## WEST SUSSEX COUNTY COUNCIL CONSULTATION

| <b>LOCATION:</b>                | Broadlees<br>Dappers Lane<br>Angmering<br>BN16 4EN                                                                                        |
| <b>SUBJECT:</b>                 | A/142/21/DOC<br>Approval of details reserved by condition imposed under A/114/18/PL relating to condition 6-Construction Management Plan. |

Max. Legal Articulated Lorry

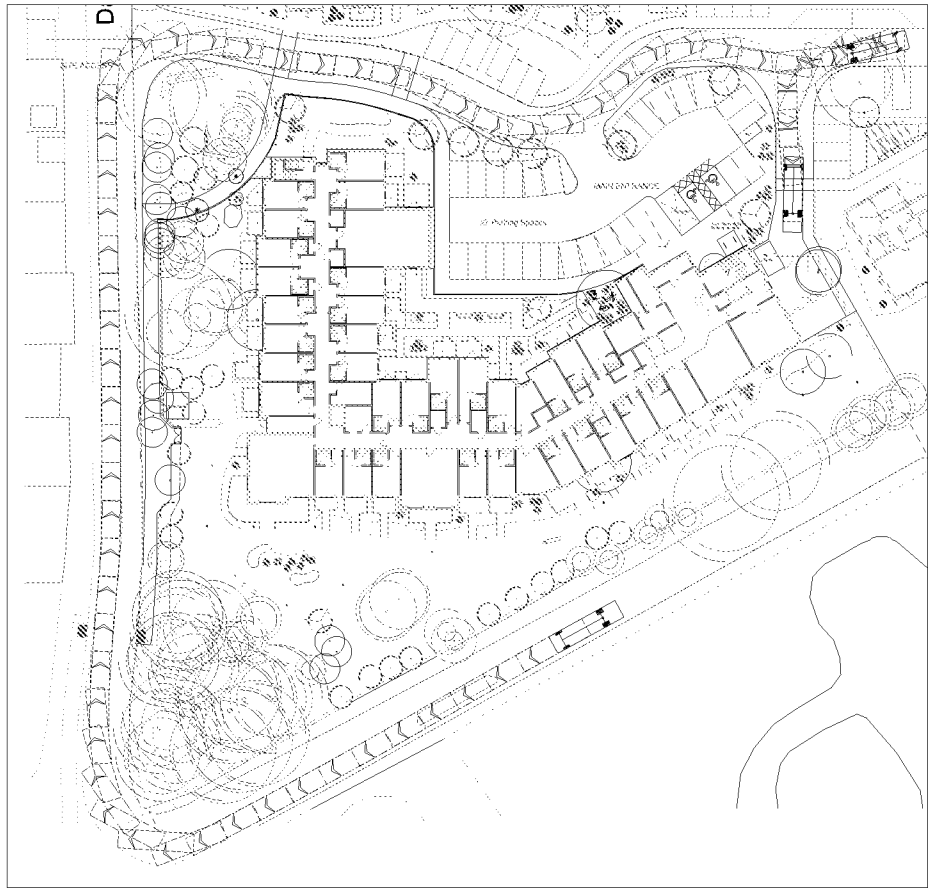
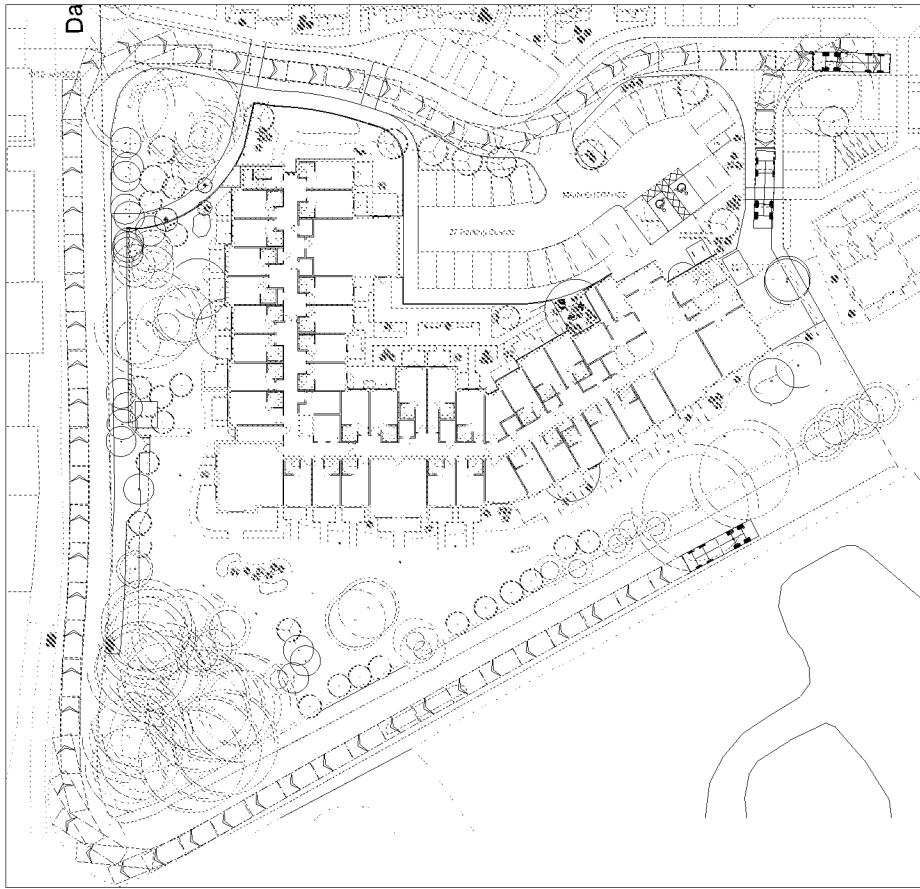
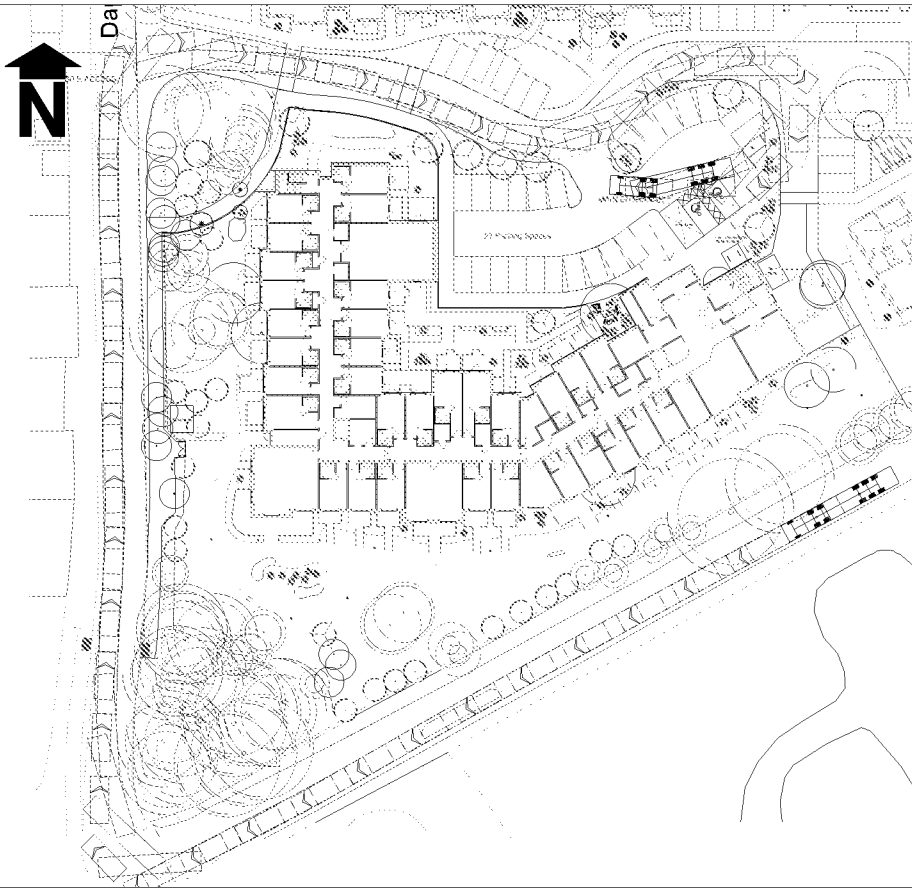
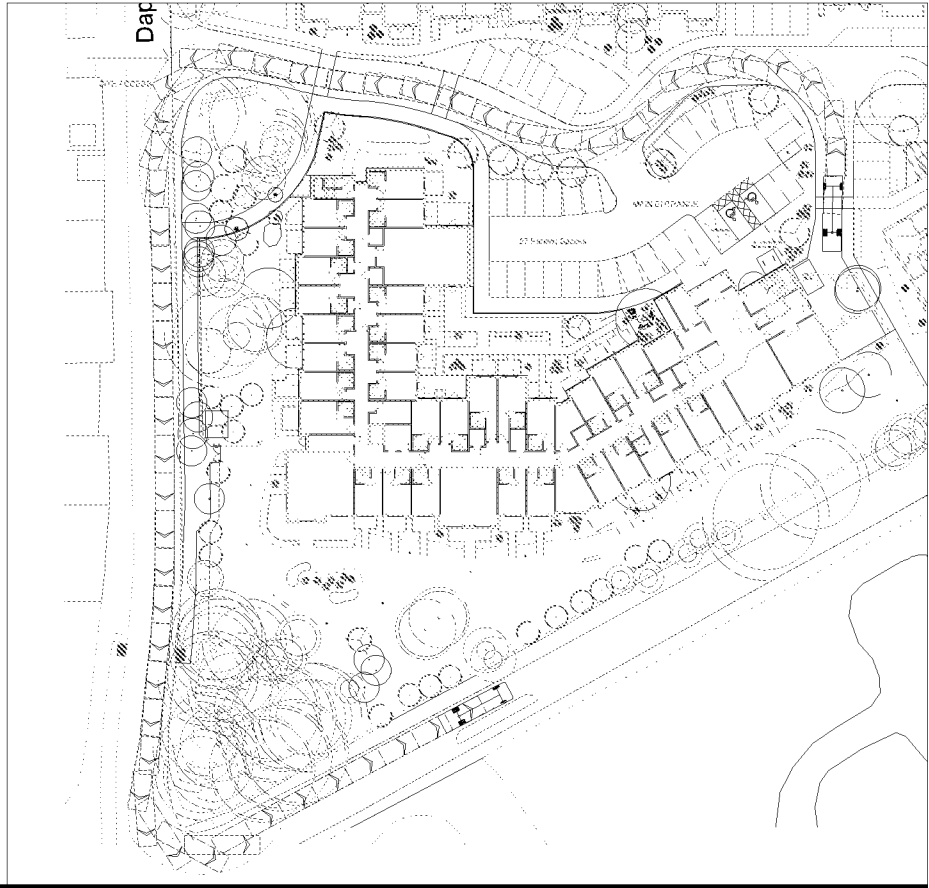
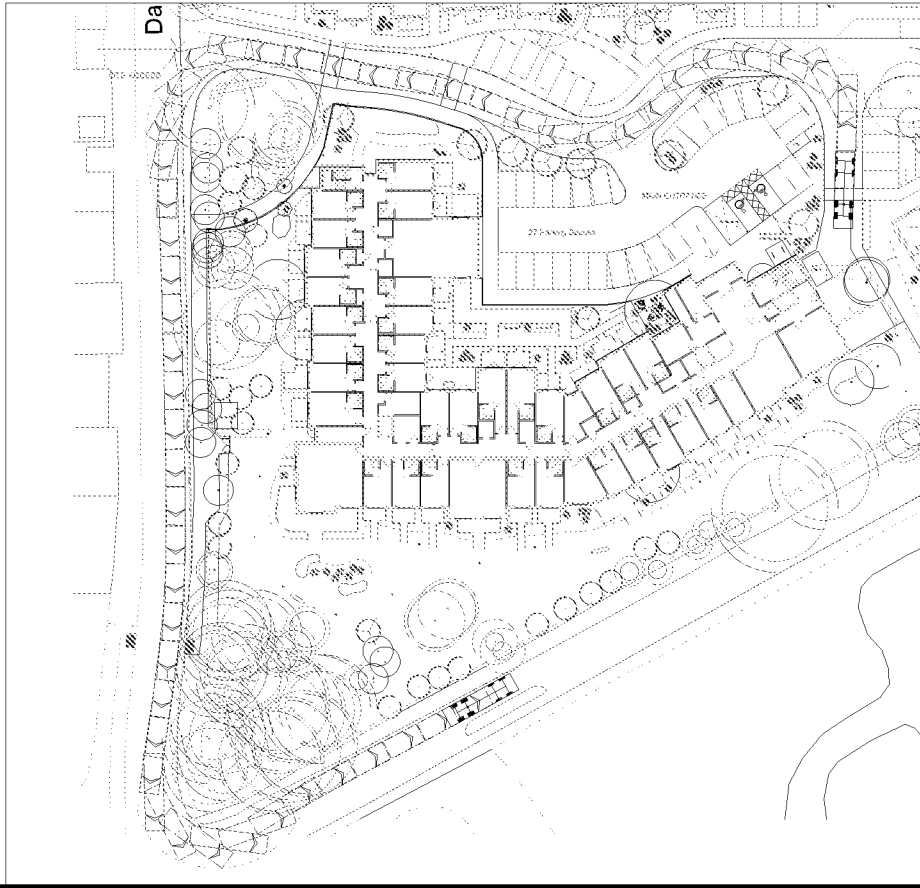
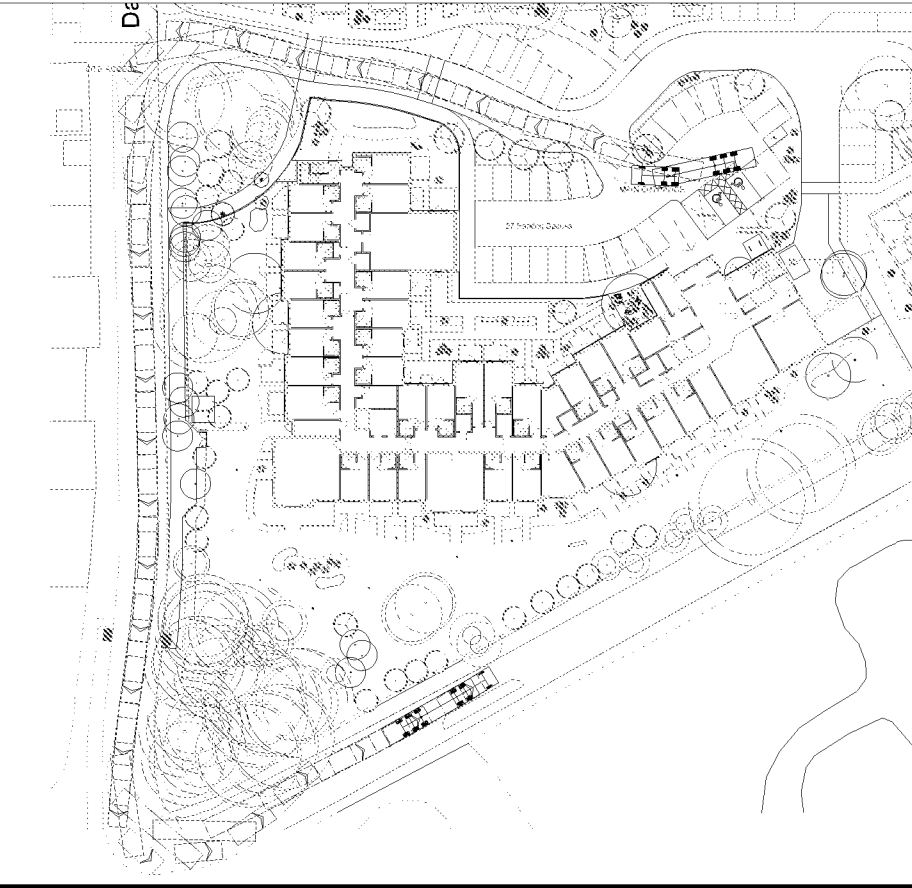
The CEMP anticipates a maximum of 8 HGV deliveries per day (and as such it is assumed 16 two way trips) these would be directed to the site from the south via Water Lane and the A280. Swept path analysis has been provided and shows a range of vehicles turning within the site. It is noted that a max length legal artic would need to over run a number of parking spaces and possibly kerb line as such it is recommended the internal kerb line is not constructed until all max length artic deliveries have been undertaken.
